From: Gary Bottwood [REDACTED]
Sent: 15 July 2021 19:11
To: Finlay Gardner <Finlay.Gardner@arun.gov.uk>
Subject: 339 Chichester Road

SITE PLAN - SHOWING VISIBILITY SPLAYS
1:500 SCALE (at A3)

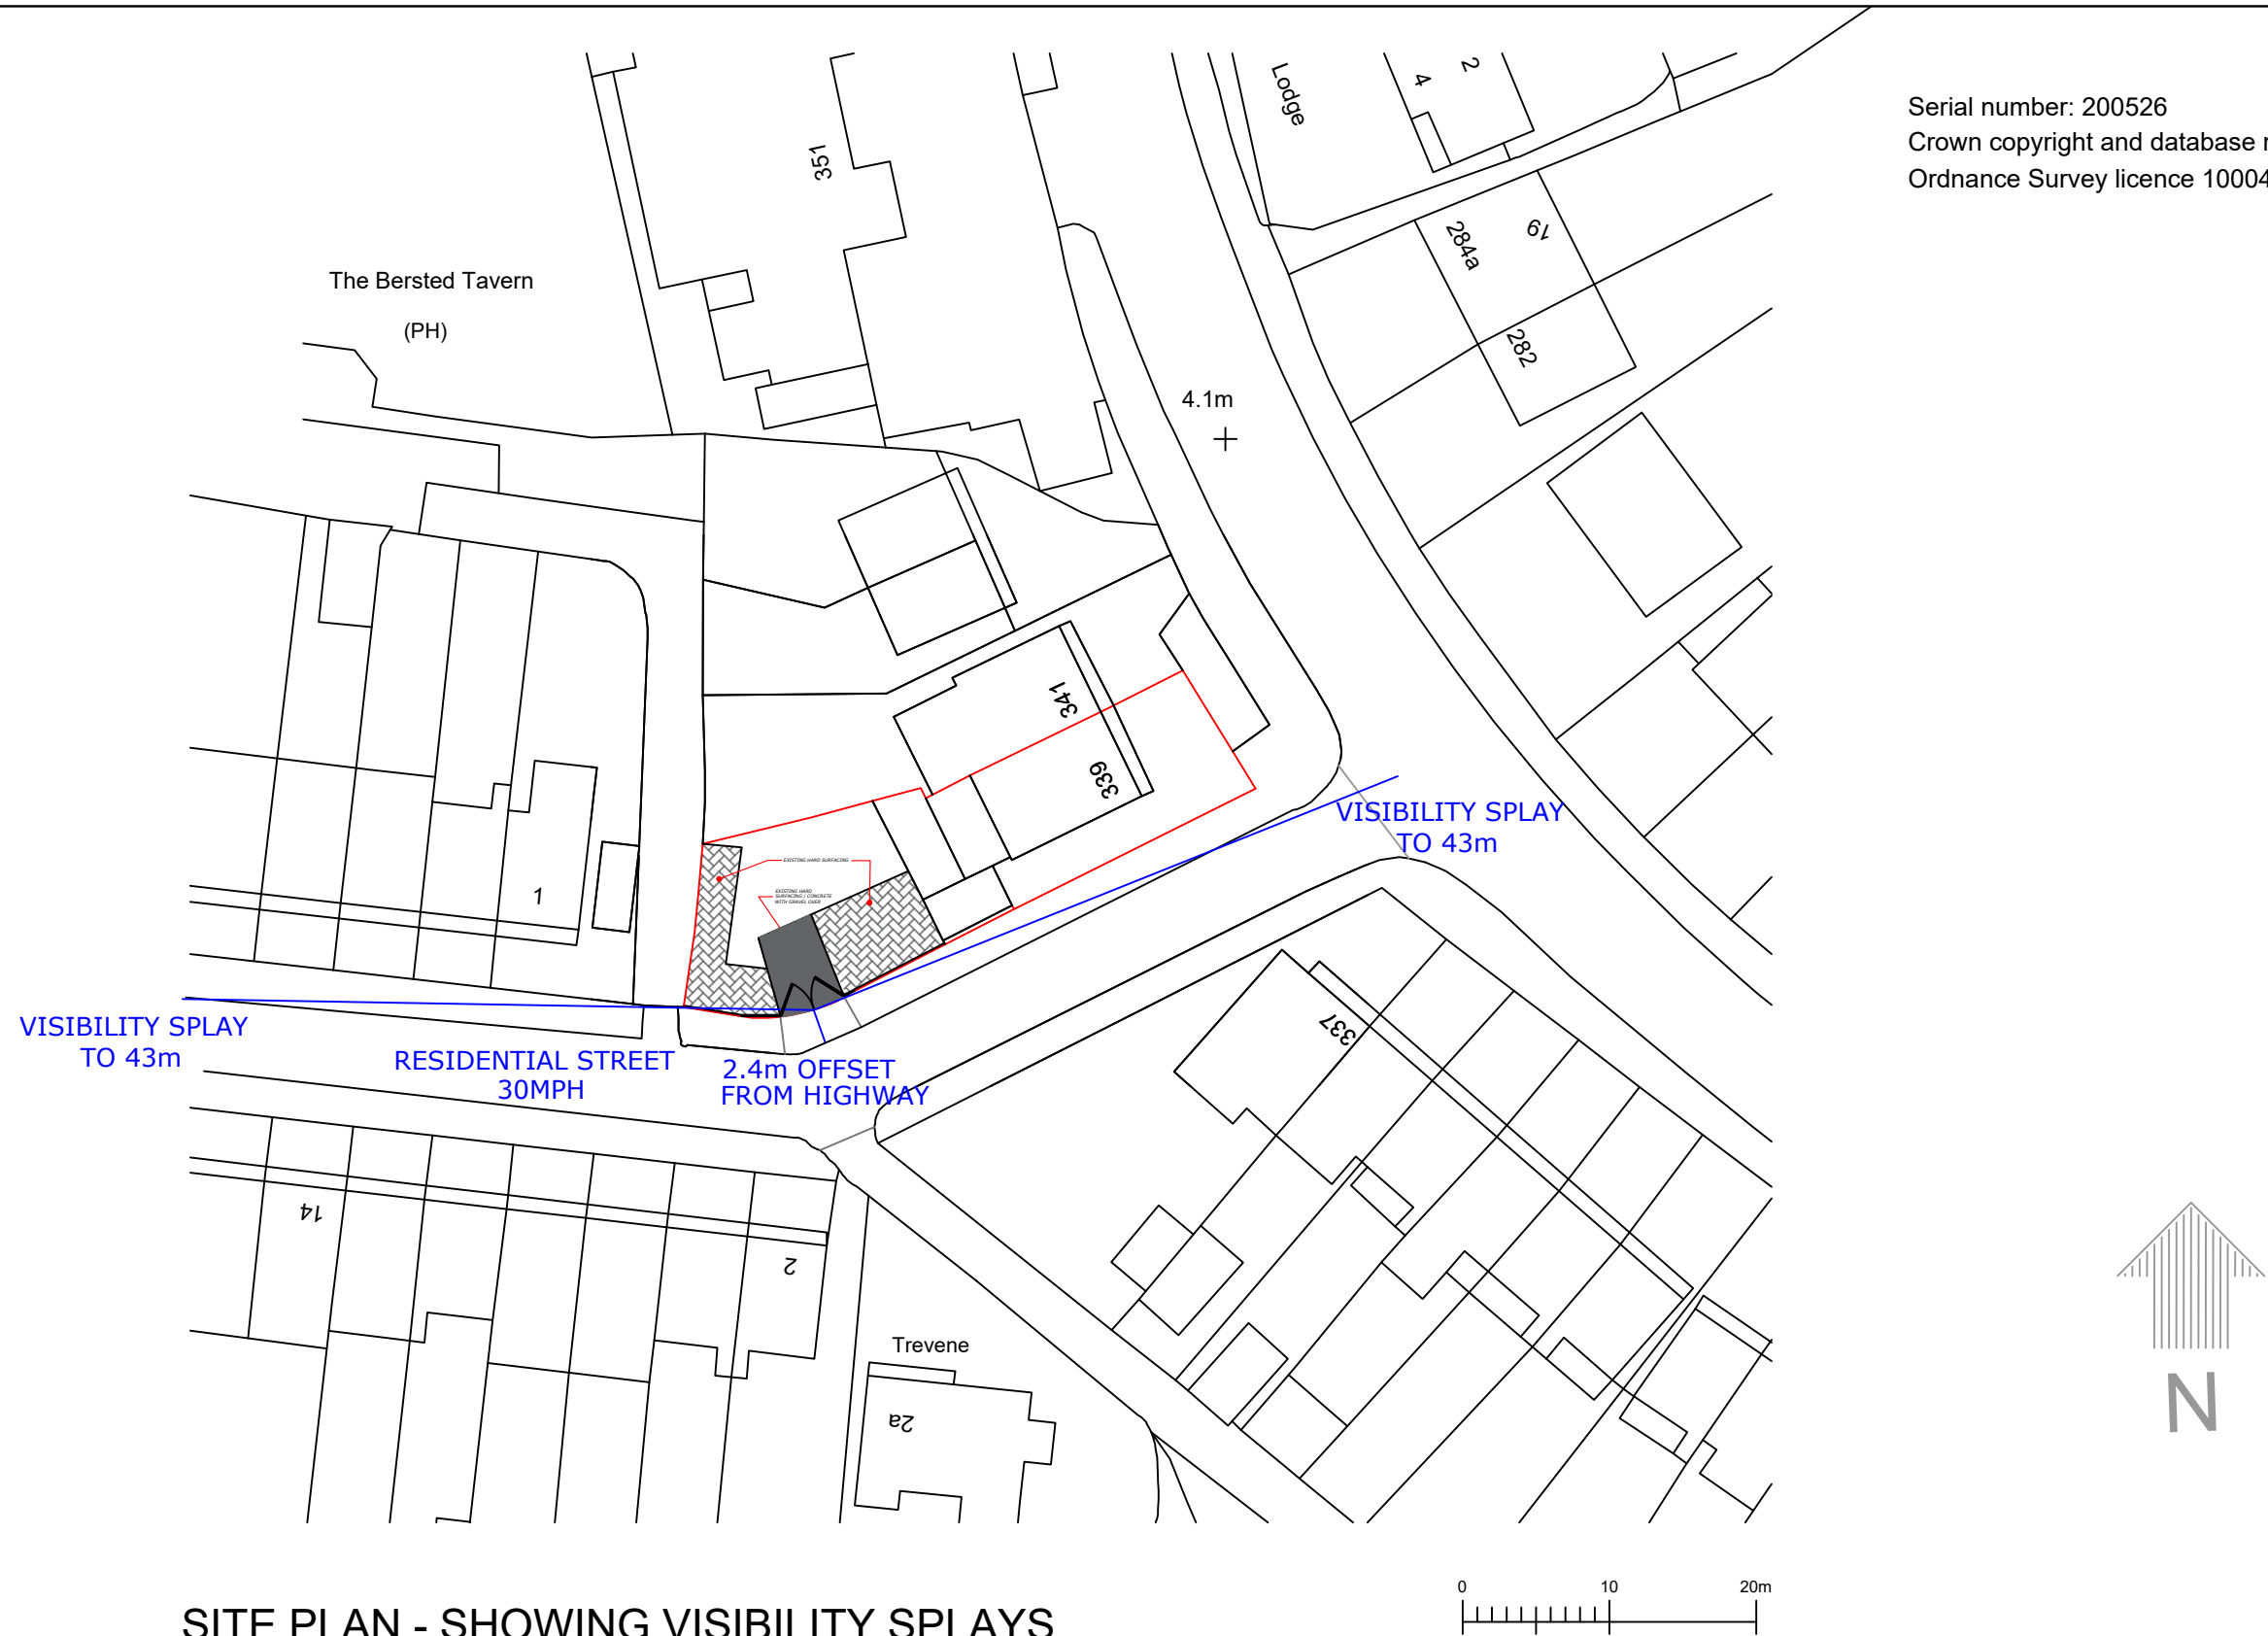
Now our opinion on the drawings has been well documented and having read the Applicants agents response is laughable. He suggests the drawings are depicting the proposed positioning of the VCO and layout of the site. He also suggests they do not reflect the exact position of the gated access rather they reflect the proposed location to achieve the Maximum Visibility.

A Proposal is a suggestion on how the Applicant sees the finished development. If the work has been carried out as in this case surely any plans should represent the finished development in the position it has been built?. To then submit drawings of the site with the Crossing in a different position can only be interpreted as nothing other than manipulation to improve their chances of having Planning approved. How are the Planning Committee Members going to be able to make an informed decision when the Plans within the Application bear no resemblance to what has already been built. It is critical Visibility requirements are met for the safety of the Public. If the Drawings show the Crossing in one place and it has been built in another how are the Committee going to assess what visibility is possible on the site or if this access meets with visibility requirements. One meter can have a drastic effect on how much visibility is available so accurate drawings are essential when dealing with Public Safety.

It is correct that WSCC Highways required the Crossing to be positioned precisely on the corner which it hasn't been. The Applicants Agent is suggesting it doesn't matter that the crossing has been installed in a different position than shown on the drawings within the Planning Application. That is ludicrous. It is critical Visibility requirements are met for the safety of the Public. This only highlights the blatant disregard for Public Safety shown throughout by the Applicant .

The Applicants agent has confirmed in his Email what we have been saying all along , the plans submitted are inaccurate and in no way represent the positioning of the Crossing. In its current location visibility of 43 meters is unobtainable and it is unlikely to be obtainable on this site at all which is why The Applicants agent manipulated the plans in the first place, to give the impression that visibility conditions can be met. If they weren't intending to mislead the Planning Department why did they not submit plans showing where the Crossing is actually positioned.

In Conclusion, We are of the mind that Mr Delaney has taken 9 Months to address the questions ,raised by yourself and others many times in this period ,only now in an attempt to justify submitting misleading plans have they tried to address this because they know the plans will be queried by the ADC Planning committee and quite possibly considered as fraudulent. They continue to use the VCO Licence being issued as justification for their not applying for Planning Permission overlooking the fact that the Licence was obtained using misinformation and possibly, again, fraudulently. and continue to ignore the conditions attached to that licence. They were aware that a site inspection by WSCC Highways was not going to happen and therefore could put the Crossing in a favourable position on the plans submitted implying visibility was adequate without any physical check taking place.. Mr Delaneys agent has admitted the Crossing isn't where it is on the plans in his comments, he has also stated the plans show where the Crossing should be to improve visibility, he has therefore confirmed the Crossing doesn't satisfy Visibility requirements as it is in a different position than in the plans submitted.
